Please ask for: Ms Iqraa Malik
Email: iqraa.malik@terraquest.co.uk
Telephone: 01212341390
Our Ref: K/20/21/HH
Your Ref:
Date: 7th May 2021

Application for Planning Permission for Works or Extension to a Dwelling

Development: Demolish existing attached garage and previous single storey extension, construct 2 storey front and side extension, part 1/2 storey rear extension and detached garage.
Location: 2 Gorse View Peak Lane Kingston BN16 1RW

Proposed Block Plan
Scale 1 : 200

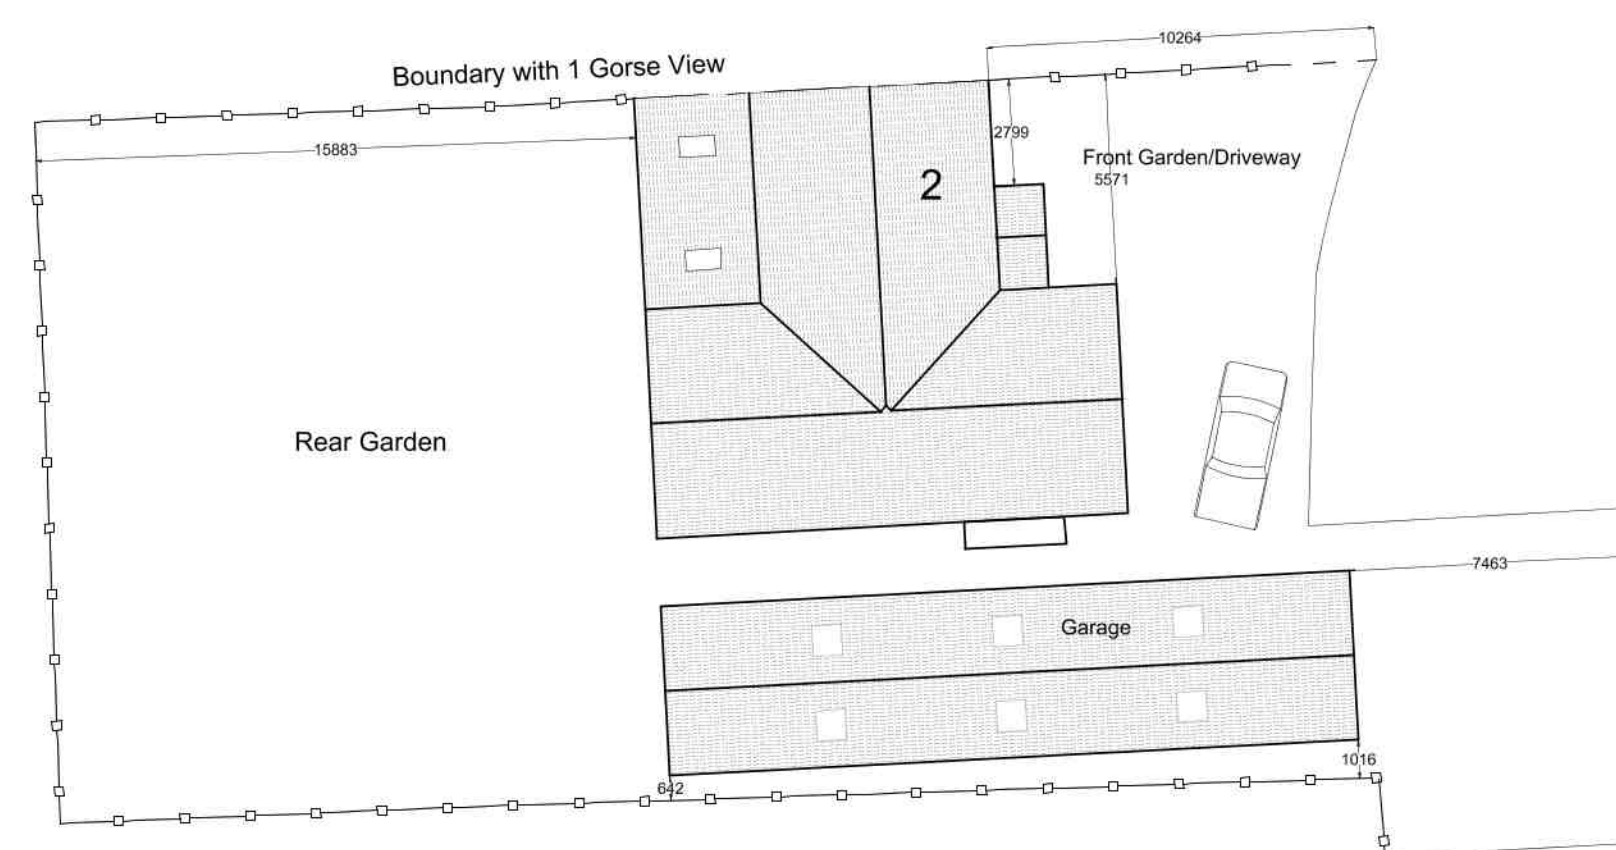
Block Plan

You are required to have dimensions from the proposed extension(s) to all site boundaries. Please amend.

Existing First Floor Plan
Scale 1 : 100

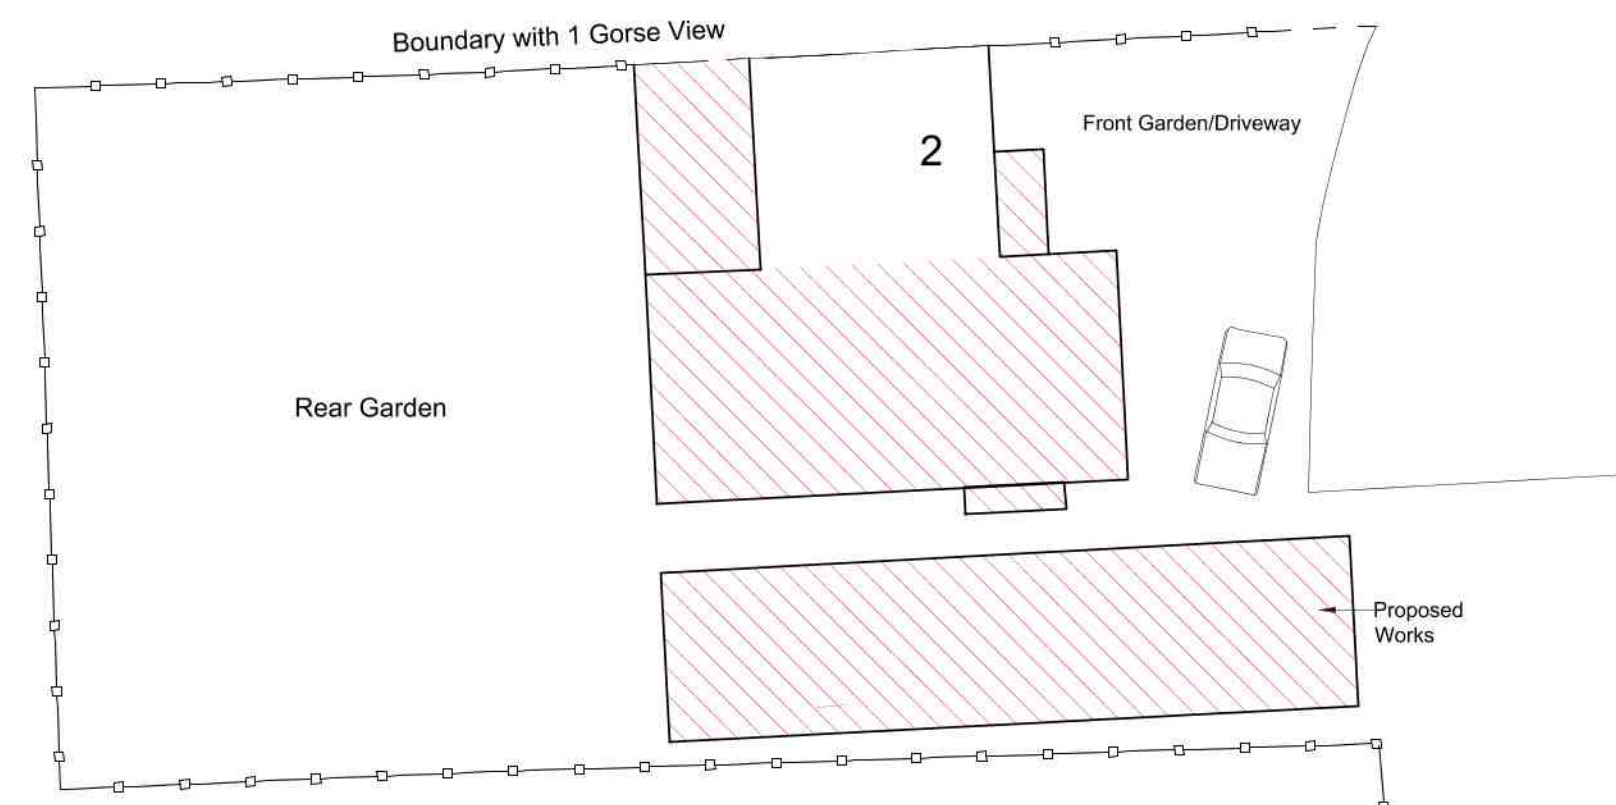
Plans

The existing side elevation window is missing from the existing first floor plan. Please review and amend accordingly.
